Appeal Decision

Appeal Ref: APP/R5510/D/20/3250793
27 Eastbury Road, Northwood HA6 3AJ

- The appeal is made under section 78 of the Town and Country Planning Act 1990 against a refusal to grant planning permission.
 - The appeal is made by Mr T Shah against the decision of London Borough of Hillingdon.
 - The application Ref 75352/APP/2020/183, dated 15 January 2020, was refused by notice dated 23 March 2020.
 - The development proposed is described as 'a two storey front extension, part two storey part single storey rear extension, conversion of roof space to habitable use to include 3 x side dormers and 3 x roof lights and conversion of garage to habitable use.'
-

PROPOSED SIDE ELEVATION
Scale 1:100

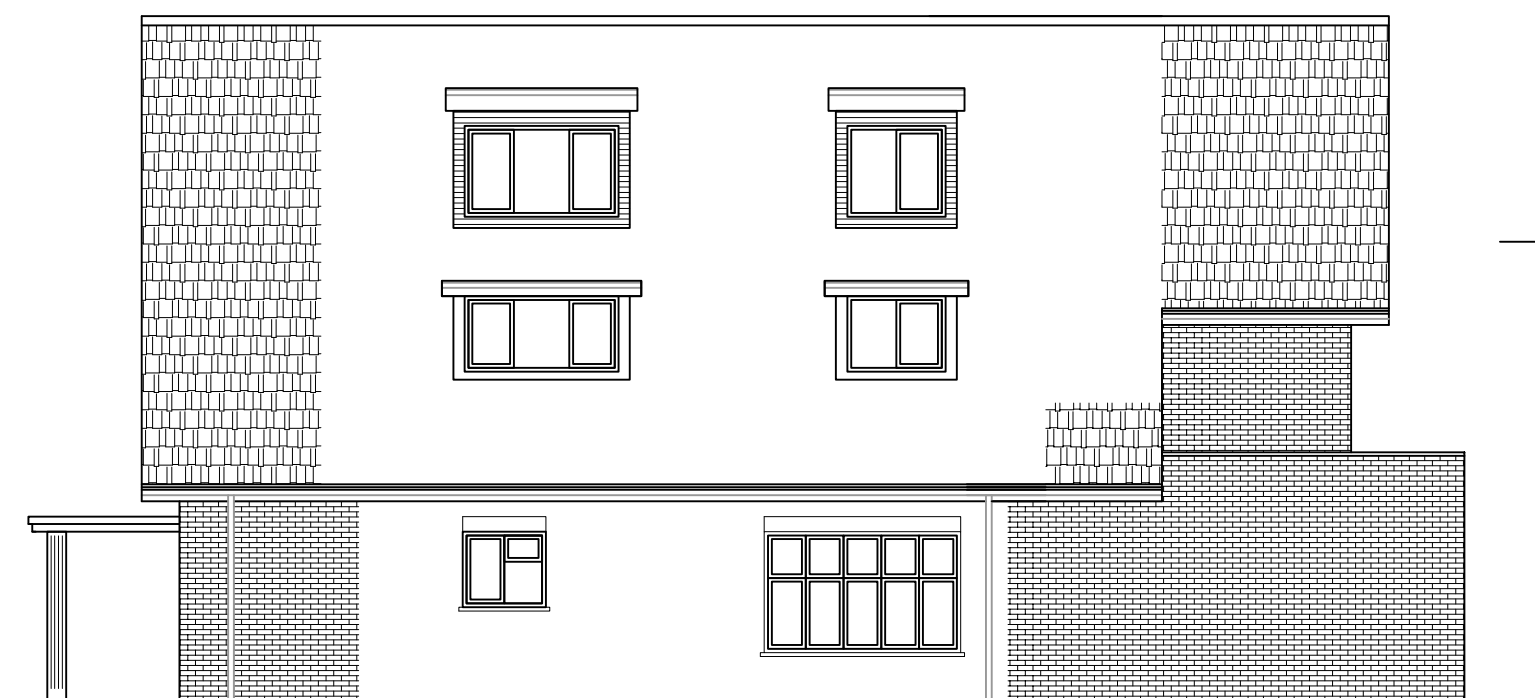
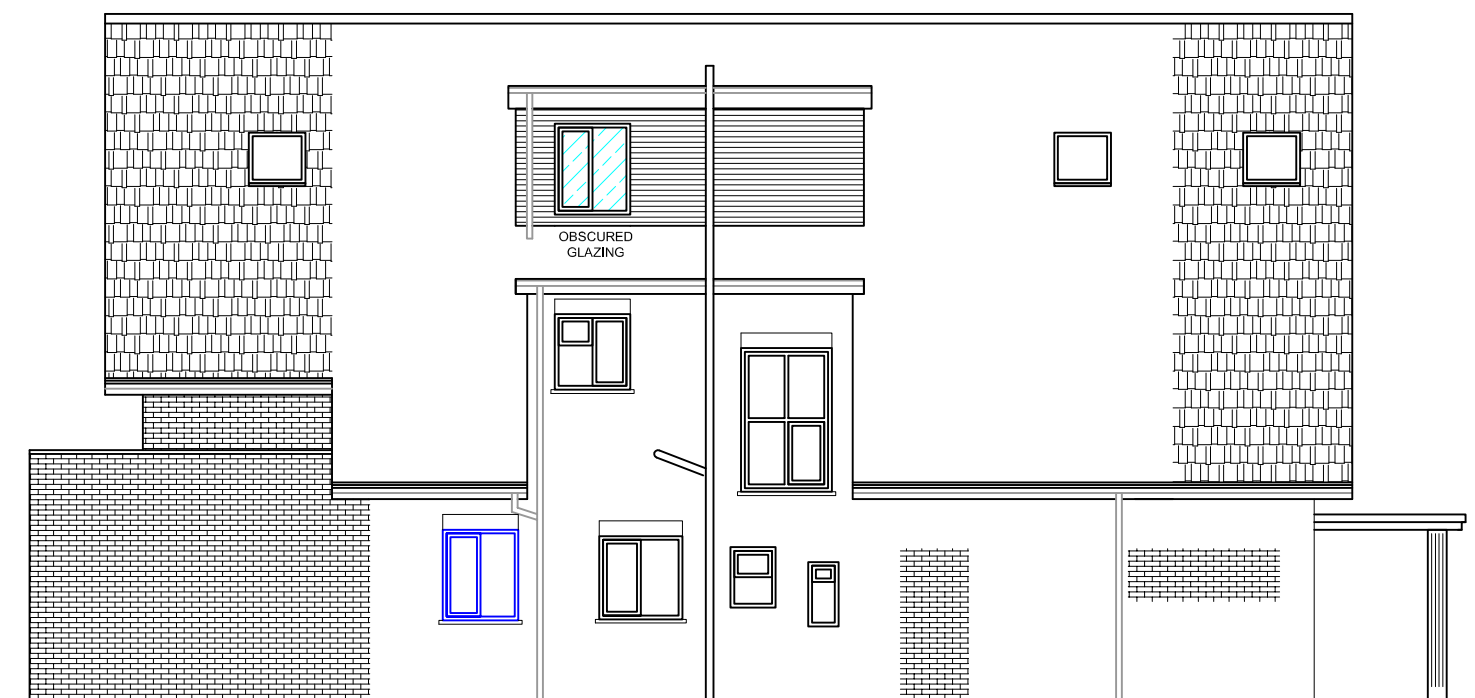
7. The appeal house has a distinct triangular roof form with existing side dormer windows set low on the roof slope and back from the front elevation. The location of the proposed dormers directly above those existing would result in an awkward roof composition with a two-tiered appearance. Although set back from the front elevation, they would be high on the roof and clearly visible from Eastbury Road even above the trees on the boundary. As a result, I find the proposed dormers would dominate the simple triangular roof appearance therein causing harm to the character and appearance of the street scene and CA.

10. In conclusion, I find the 3 x side dormers would cause harm to the appearance of the street scene and fail to preserve or enhance the character and appearance of the Northwood Frithwood Conservation Area. This conflicts with Policies BE1 and HE1 of the Hillingdon Local Plan: Part One – Strategic Policies (2012), and Policies DMHB4 of the Local Plan: Part 2 – Development Management Policies (2020) (DMP). Amongst other things, these policies seek to ensure development does not result in harm to heritage assets and maintains the quality of an area.
11. I am satisfied that the other extensions serve to preserve the character and appearance of the CA and do not conflict with any of the policies listed above. There is also no conflict with DMP Policy DMHD1 because the front extension would not alter the overall appearance of the house or dominate the character of the street.

1. The appeal is dismissed insofar as it relates to 3 x side dormers. The appeal is allowed insofar as it relates to a two storey front extension, part two storey part single storey rear extension, conversion of roof space to habitable use to include 3 x roof lights and conversion of garage to habitable use and planning permission is granted for a two storey front extension, part two storey part single storey rear extension, conversion of roof space to habitable use to include 3 x roof lights and conversion of garage to habitable use at 27 Eastbury Road, Northwood HA6 3AJ in accordance with the terms of application, Ref 75352/APP/2020/183, dated 15 January 2020, and the plans submitted with it, so far as relevant to that part of the development hereby permitted and subject to the following conditions:

8. The appeal house is currently 2-storey with its gable fronting Eastbury Road. The proposed front extension would align with the existing projecting garage bringing the building broadly in line with its neighbour at No.25 Eastbury Road. Although closer to the road, it would remain set well back and the original form and overall appearance would be retained. Importantly, the triangular roof of the original house, which the Council consider distinctive and adds interest to the street scene and CA, would not be lost.

9. The white banding over the converted garage replicates the existing and provides relief and interest to an otherwise brick elevation. Whilst the proposed ground floor windows on the front elevation would not match, they would be of a similar design and proportions and I find these appropriate to the simple architecture of the house. The proposed double front door with open porch would be more prominent than the recessed single front door of the original house. It would, however, be in proportion to the scale of the front elevation and would not overly dominate it. Overall, I find the architectural detailing to the front elevation to be sympathetic to the composition of the house and would not harm its appearance.
